**EPC STORMWATER REVIEW COMMENTS  
IN ORANGE BOXES WITH BLACK TEXT**

**SMALL SUBDIVISION FINAL DRAINAGE REPORT  
FOR  
CLOVERLEAF FILING NO. 1**

**December 1, 2020**

**Add text:  
PCD Filing No.: SF-21-014**

PROPOSED DRAINAGE MAP

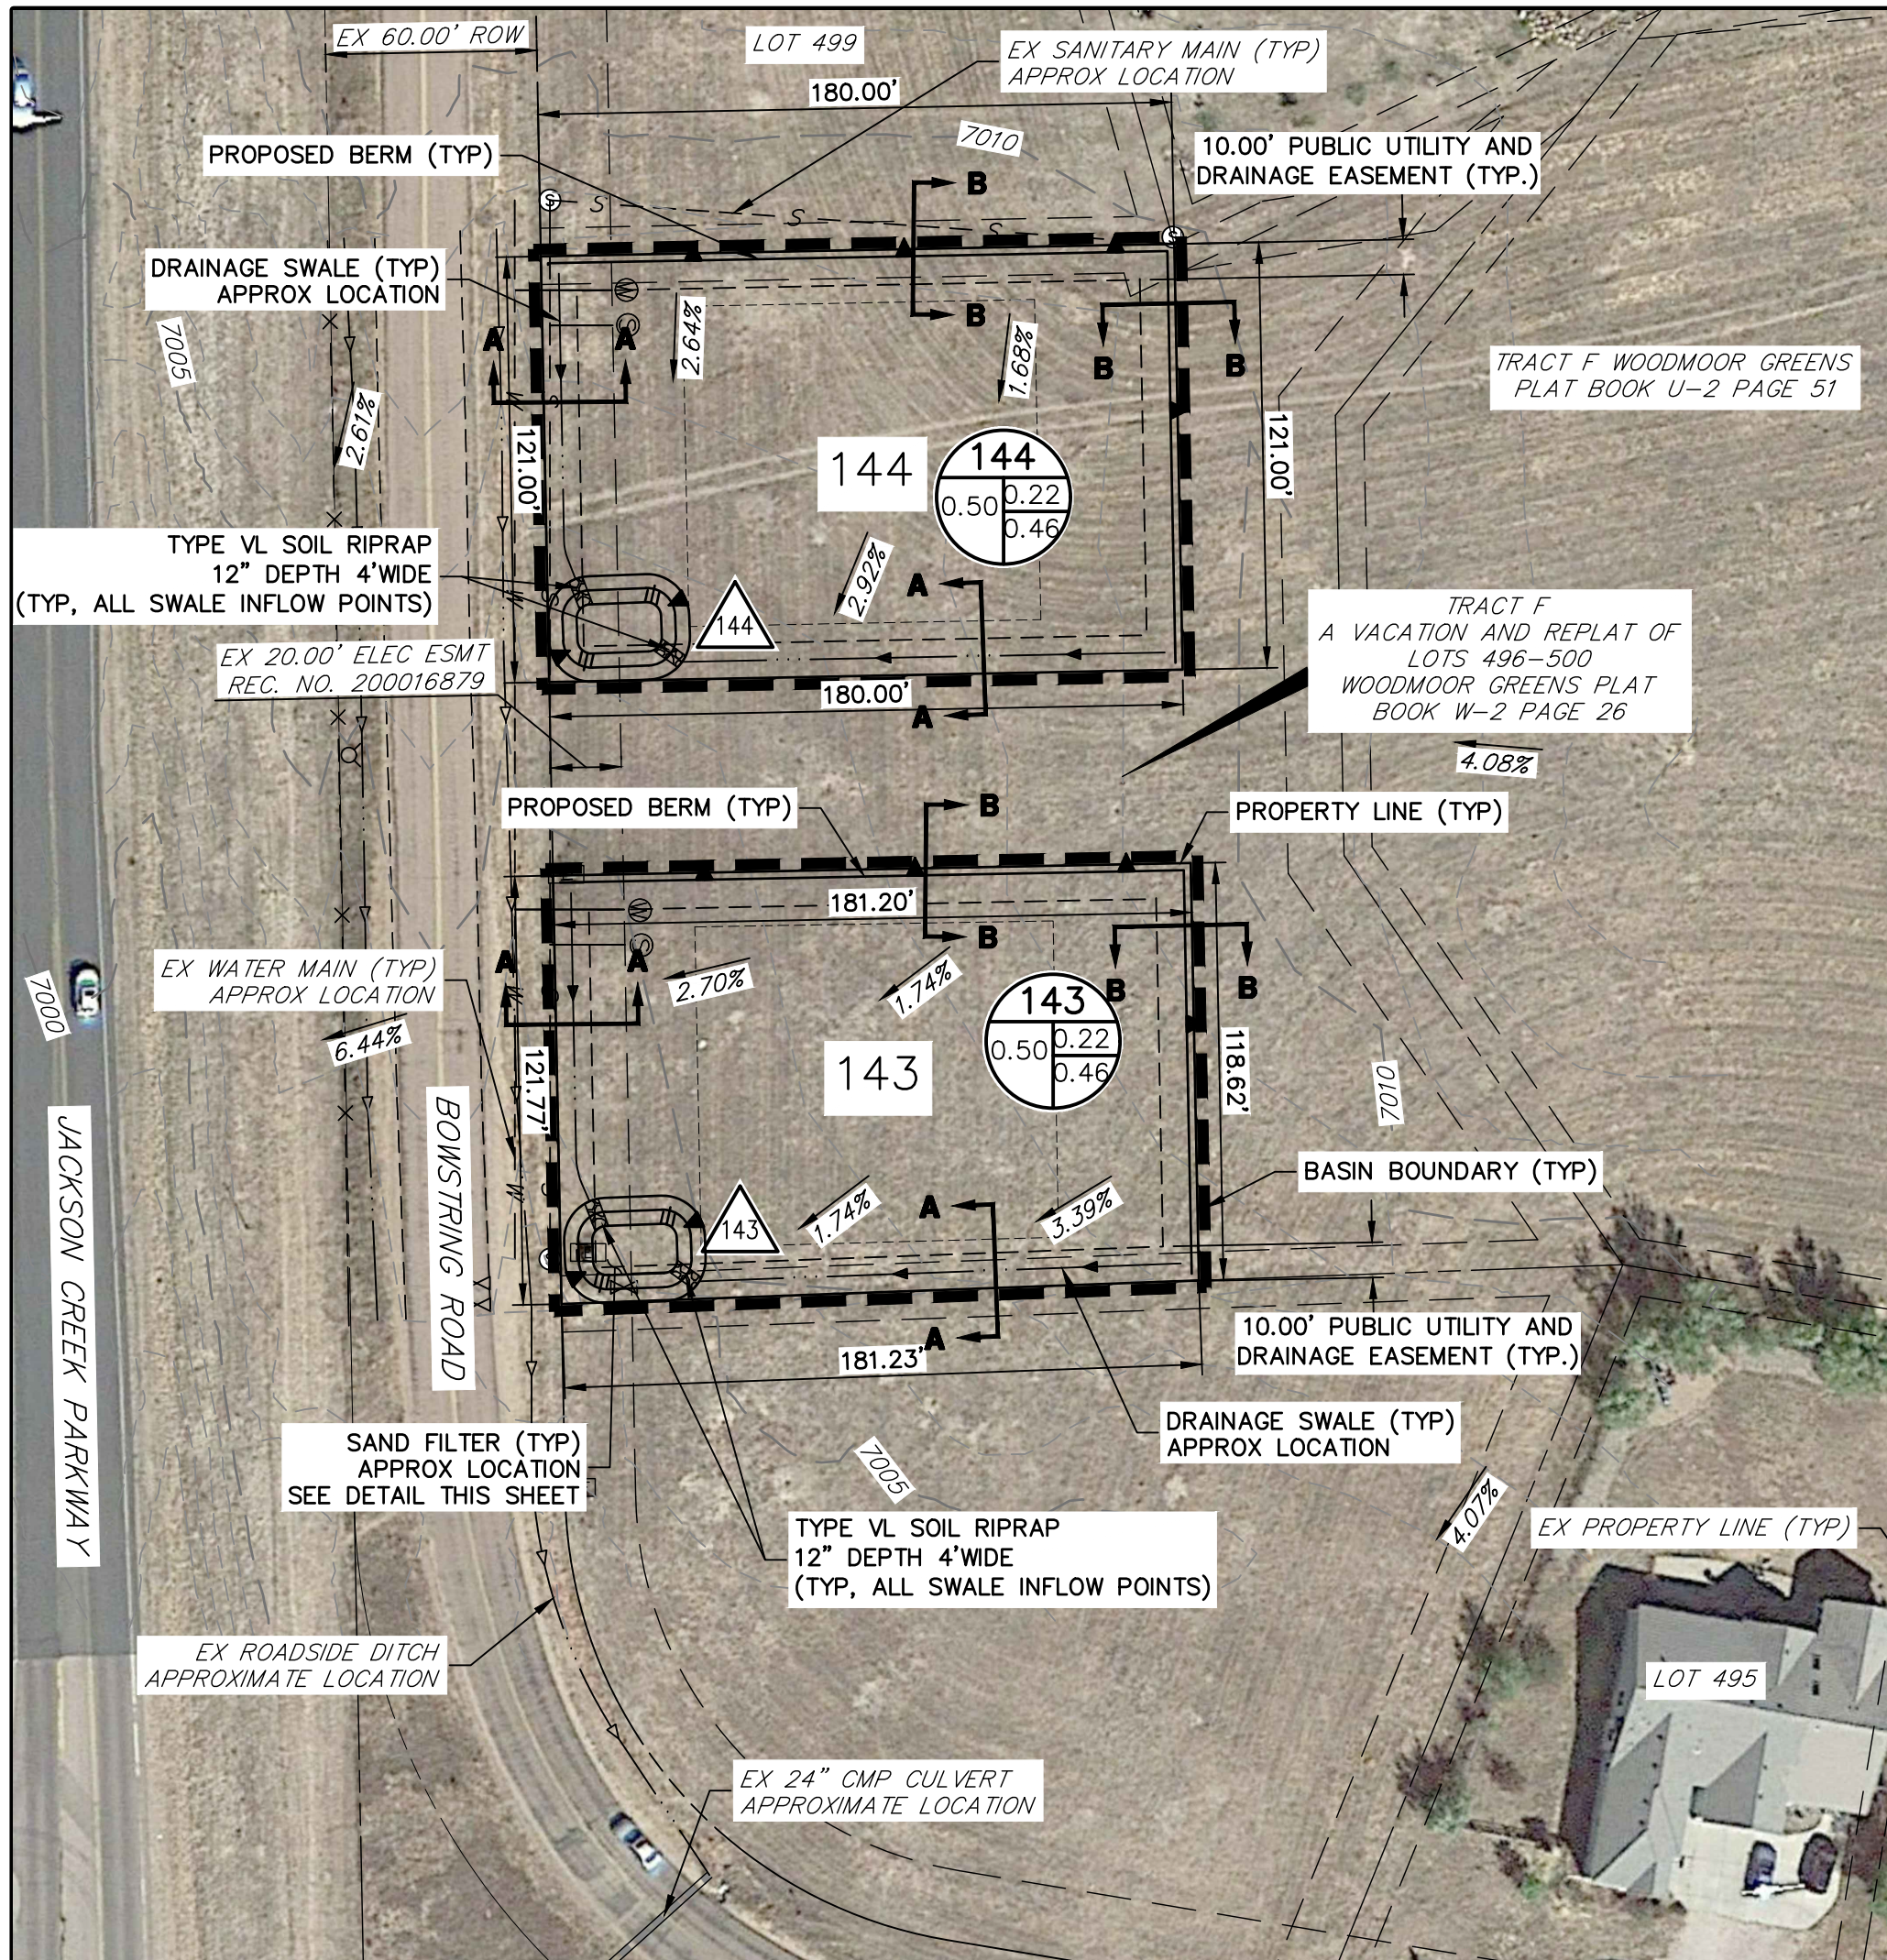
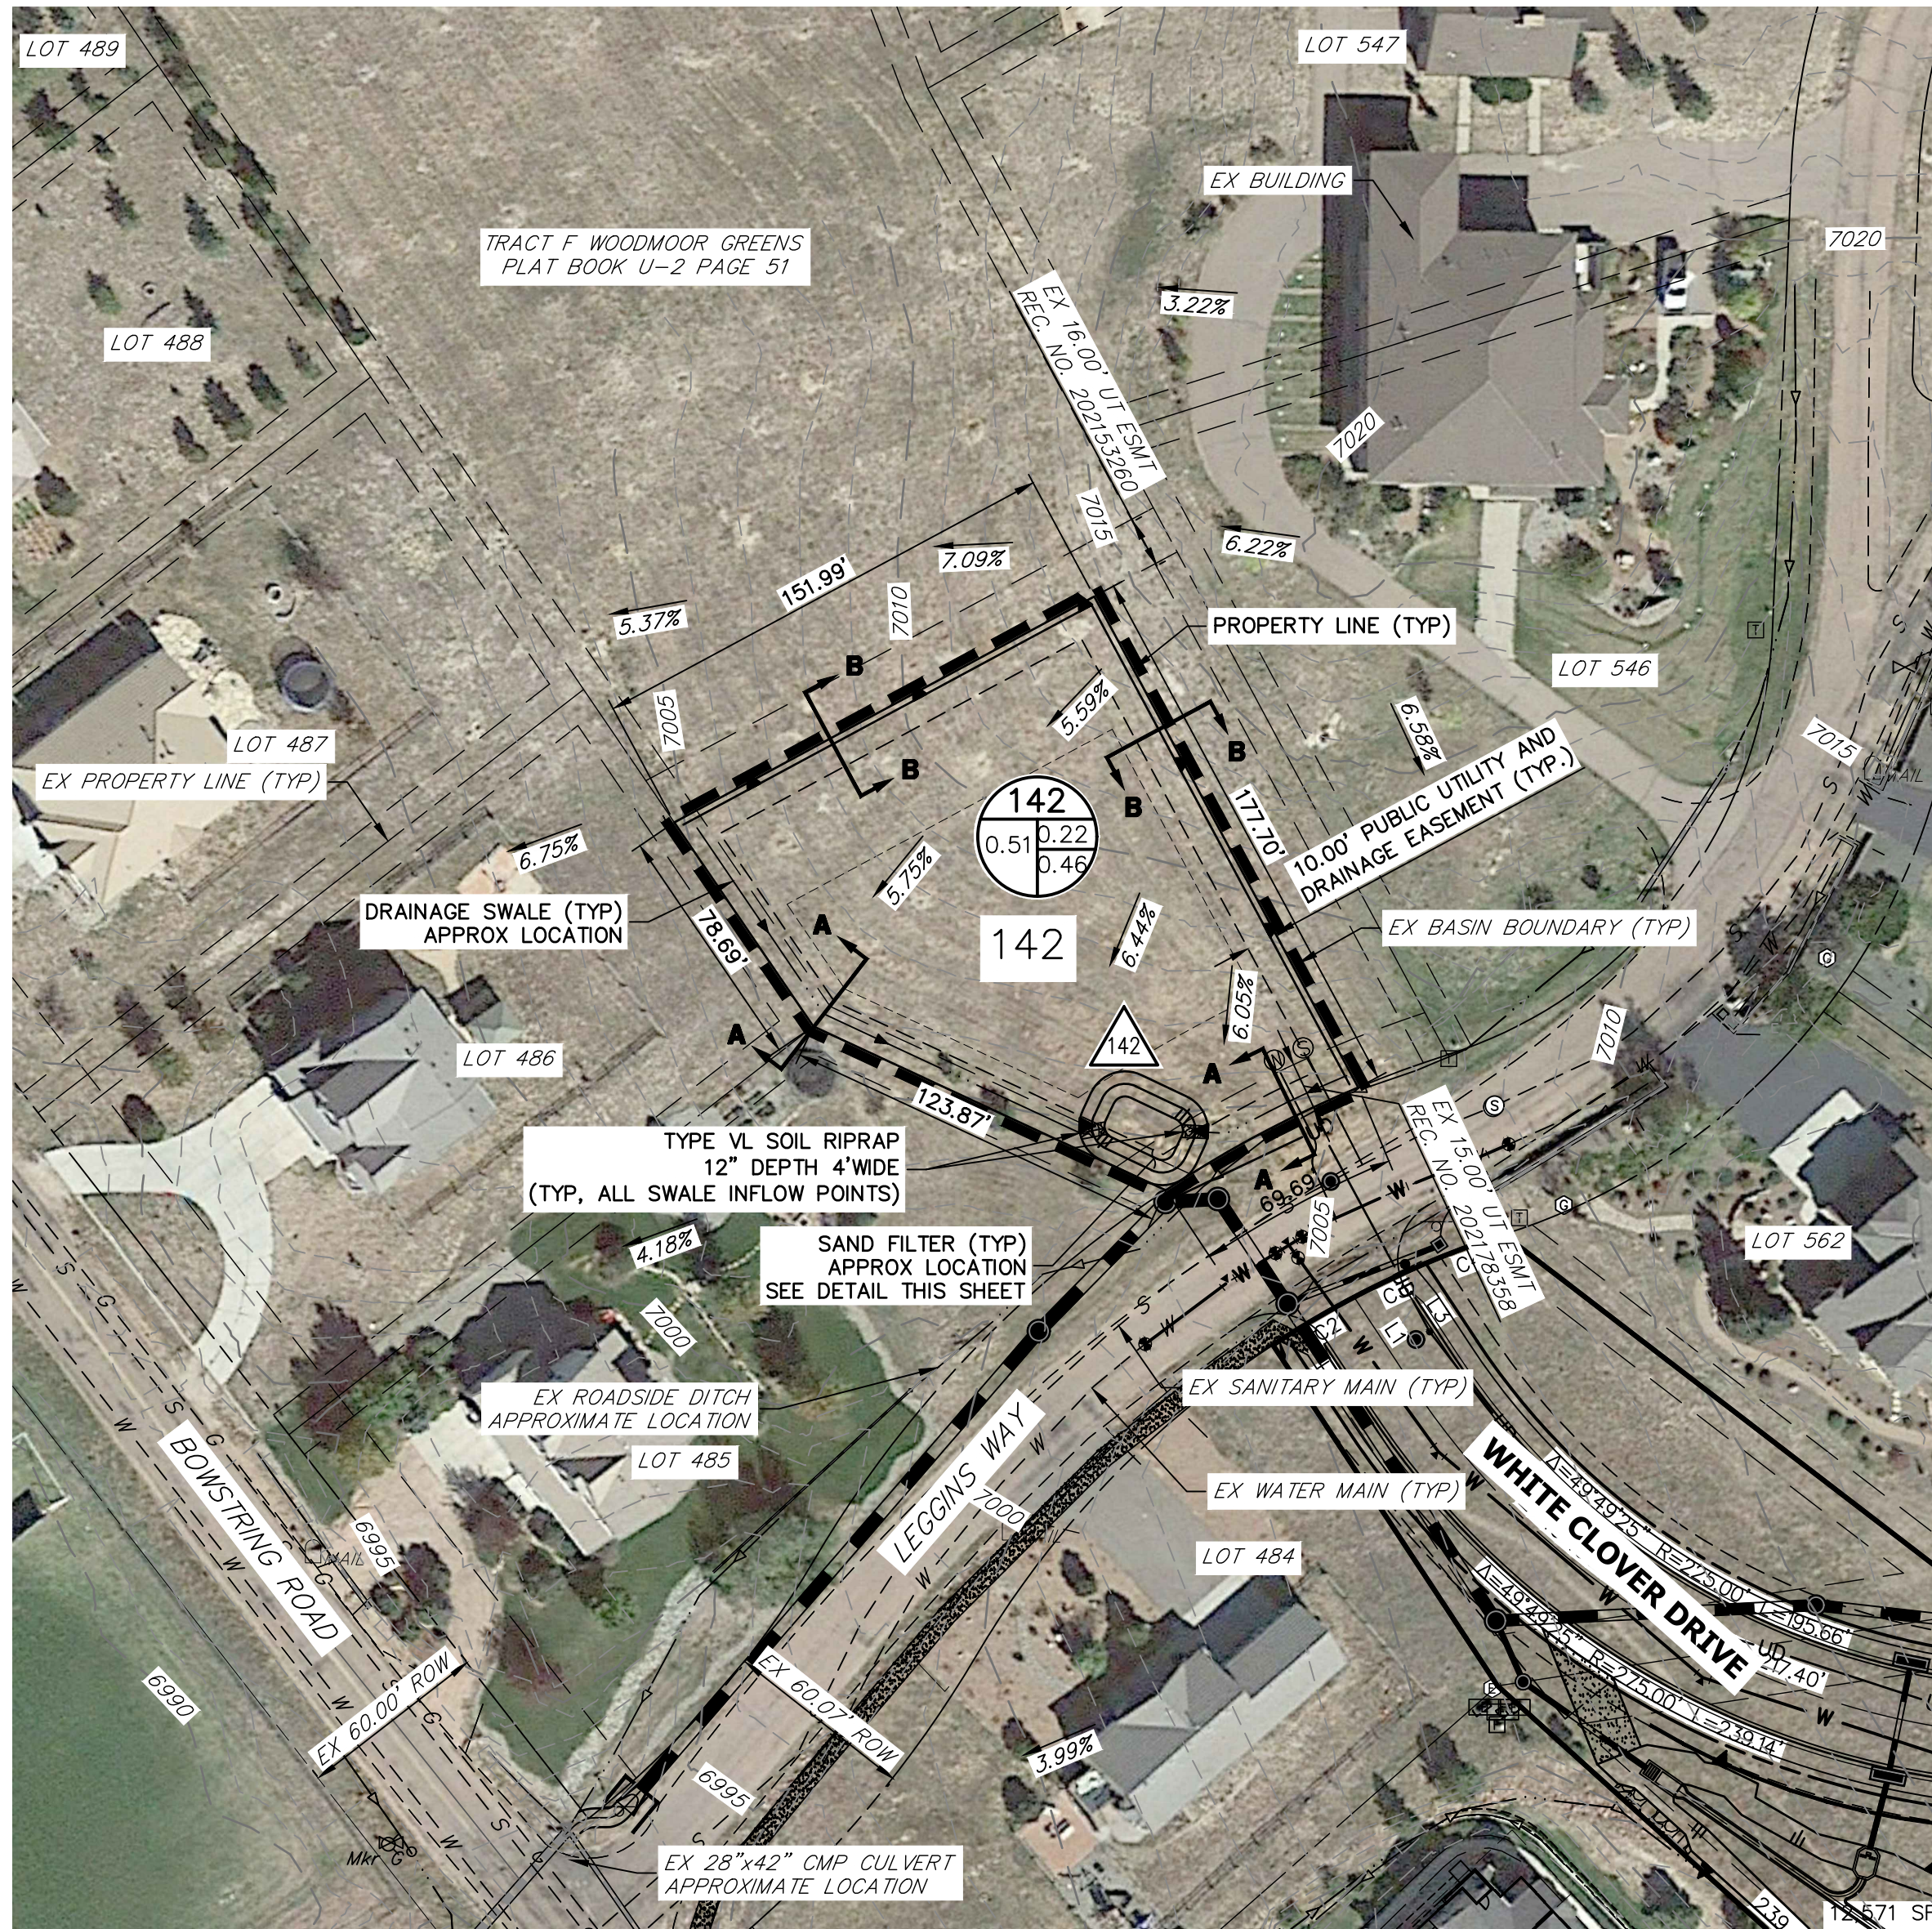
Please explain how. Is there a berm around the property to prevent offsite flow from entering the site? It looks like the land to the east of lots 143 and 144 flows onto these lots.  
If needed, include tributary basins into the rational method calcs in Appendix B

Addressed: Section details consisting of berms and swales were added to the proposed drainage map to demonstrate the anticipated lot grading. In general, berms will be installed on the uphill sides of lots where offsite flows currently enter the lots. The berms will route the offsite runoff around the lots and back to their existing drainage paths on the downstream side. Swales will intercept on-site generated runoff and transport it to the proposed Full-Spectrum SF's.
